DECISION DELEGATED TO HEAD OF PLANNING

Application No: H01-0759-24 **Applicant:** Mr J Negus
Proposal: Residential Development - Erection of One and Half Storey Dwelling
Location: Adj. Croft House 98 Stone Gate Cowbit
Terminal Date: 29th November 2024

3314.S02.R1

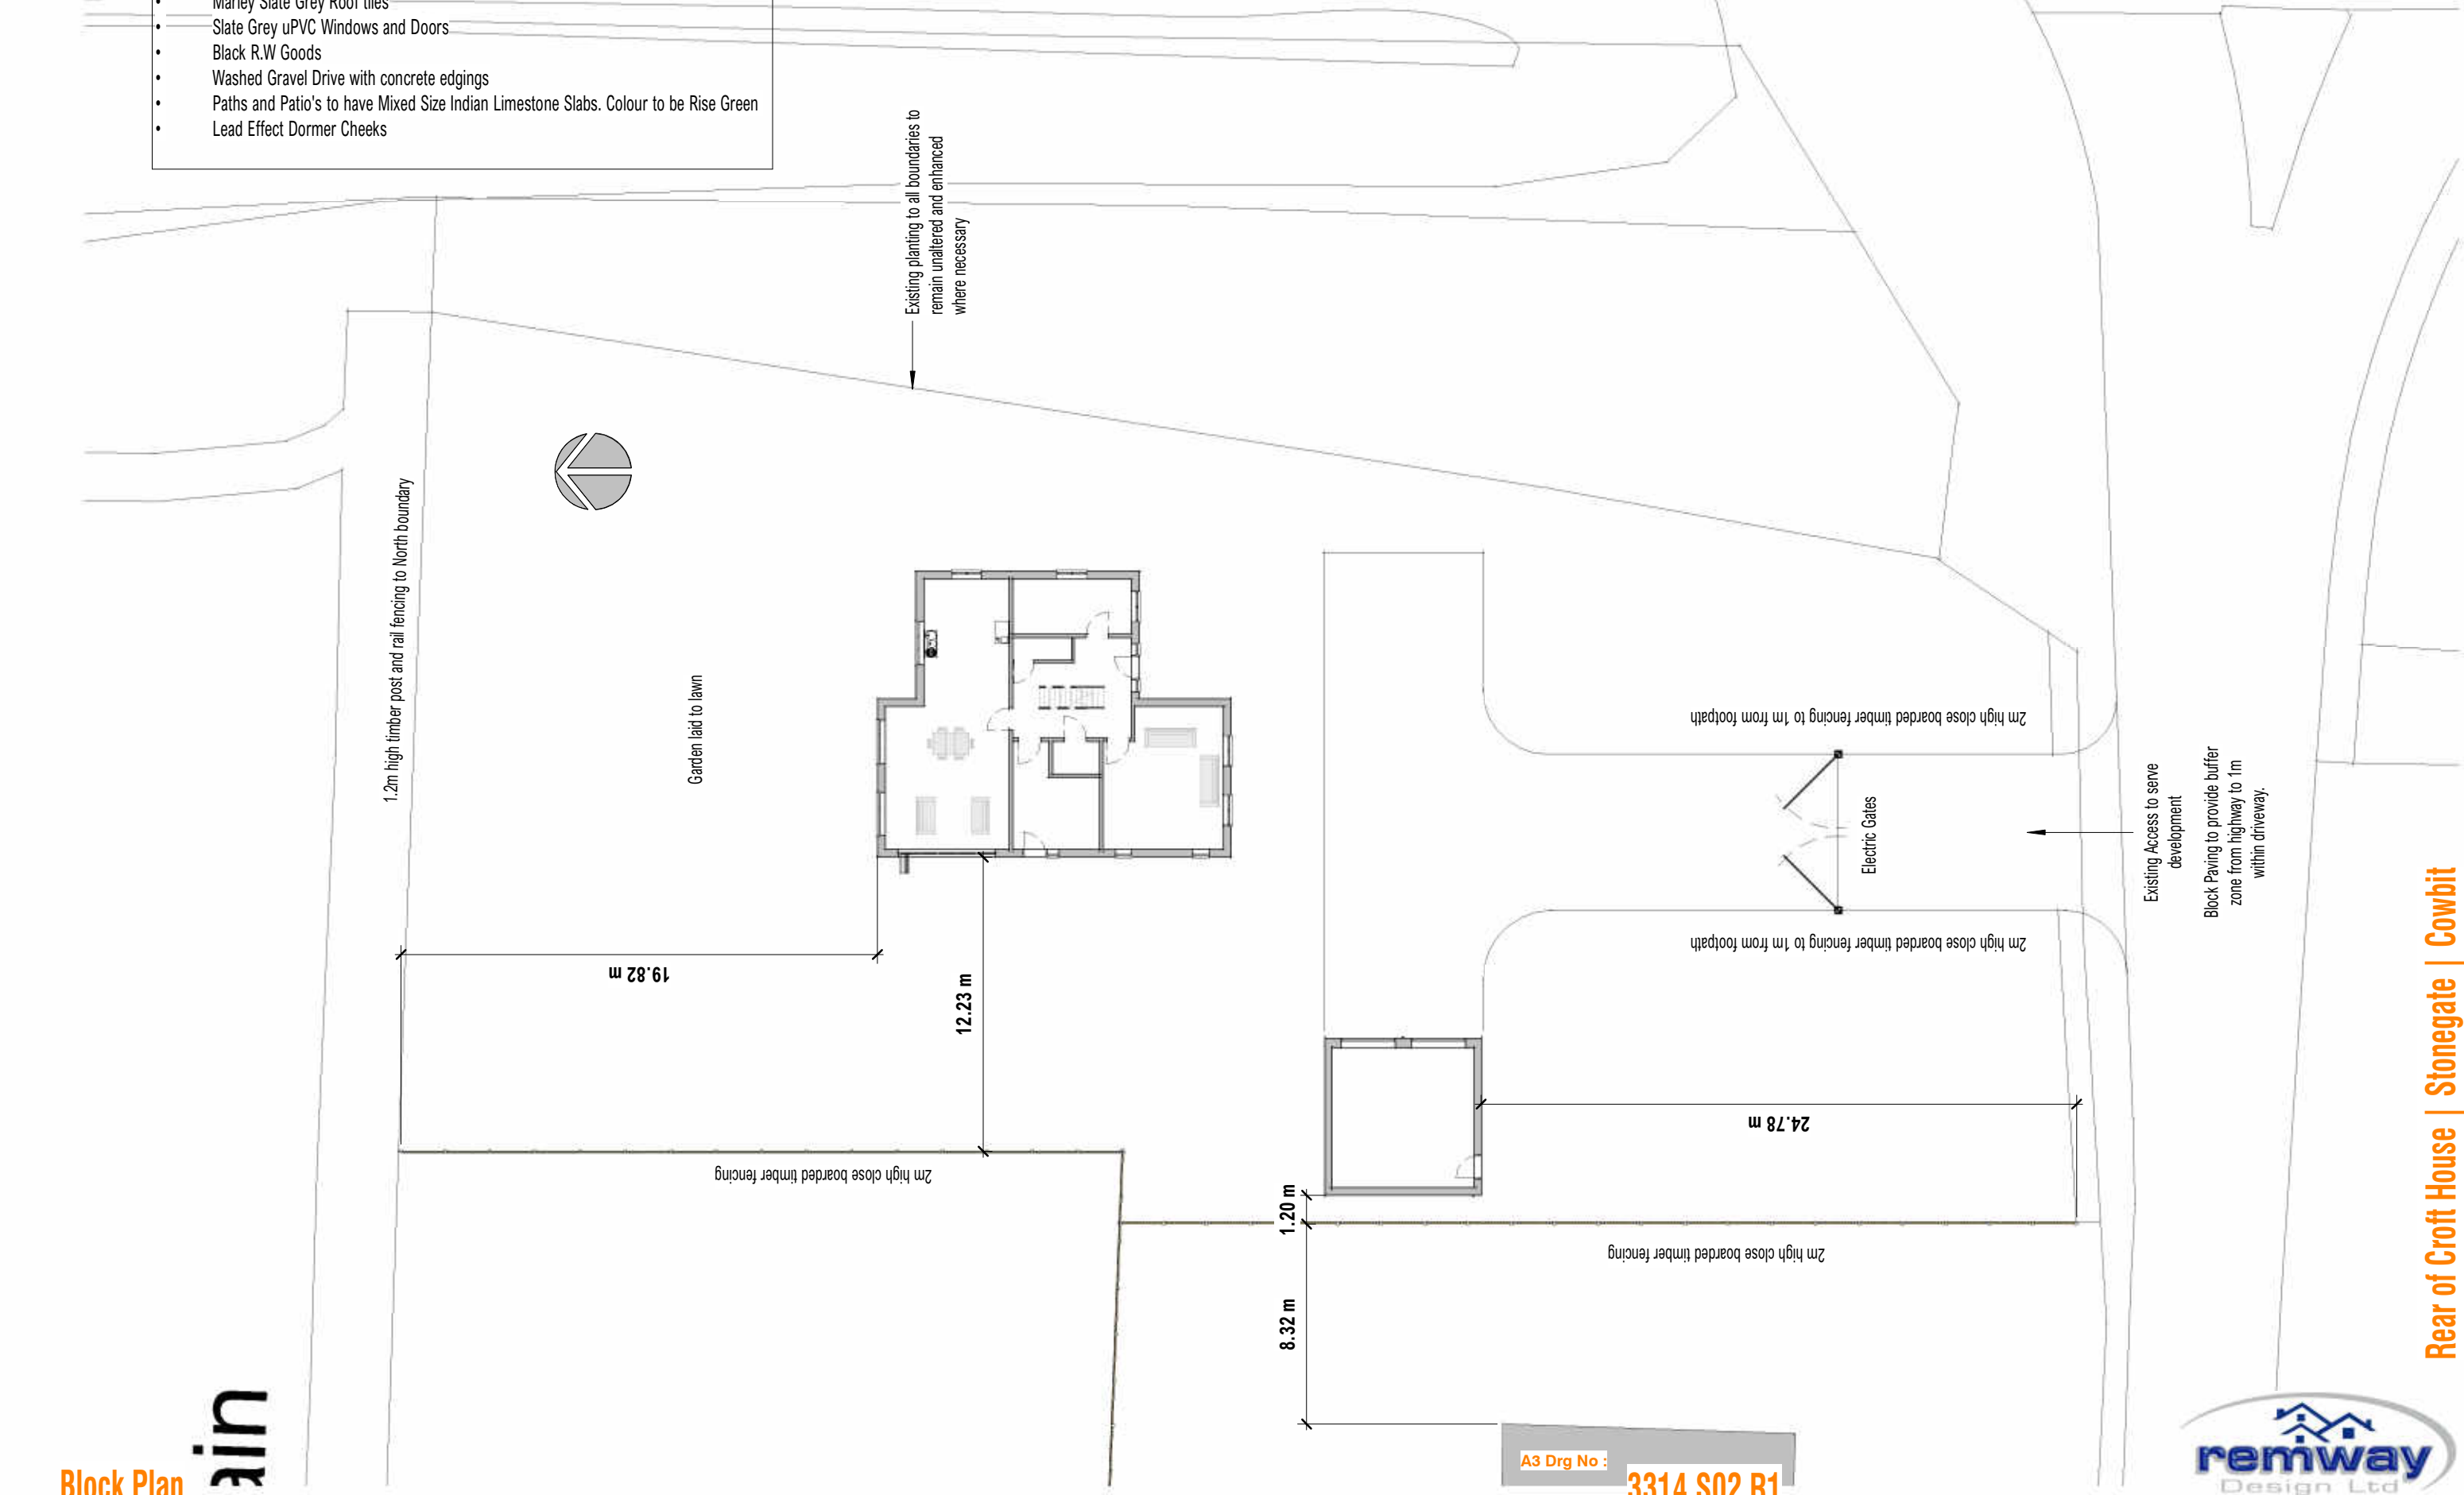
Please demonstrate visibility in accordance with Manual for Streets. Block paved accesses do not form part of our specification - the access should be constructed of tarmac. How will residents of the proposed dwelling walk safely to the footway network into the Village? This is a busy road where the speed limit only just reduces to 30mph from the national speed limit and the site is very close to the roundabout.

The proposal is to utilise and upgrade an existing access from Stone Gate. Parking provision is shown on plan as well as a detached garage. Highways have expressed concerns in relation to the visibility and it is not clear whether this has been resolved through an amended block plan, though concerns in relation to pedestrian access both to and from the property still clearly remain. The applicant also proposed to keep the high treatment to the front of the property.

It is considered that despite this given an existing access is already in situ and that Croft House does not connect to the pedestrian footway network that this could fairly be refused on highway safety grounds. Any permission achieved however would need to provide some form of footway connection along the front of the site.
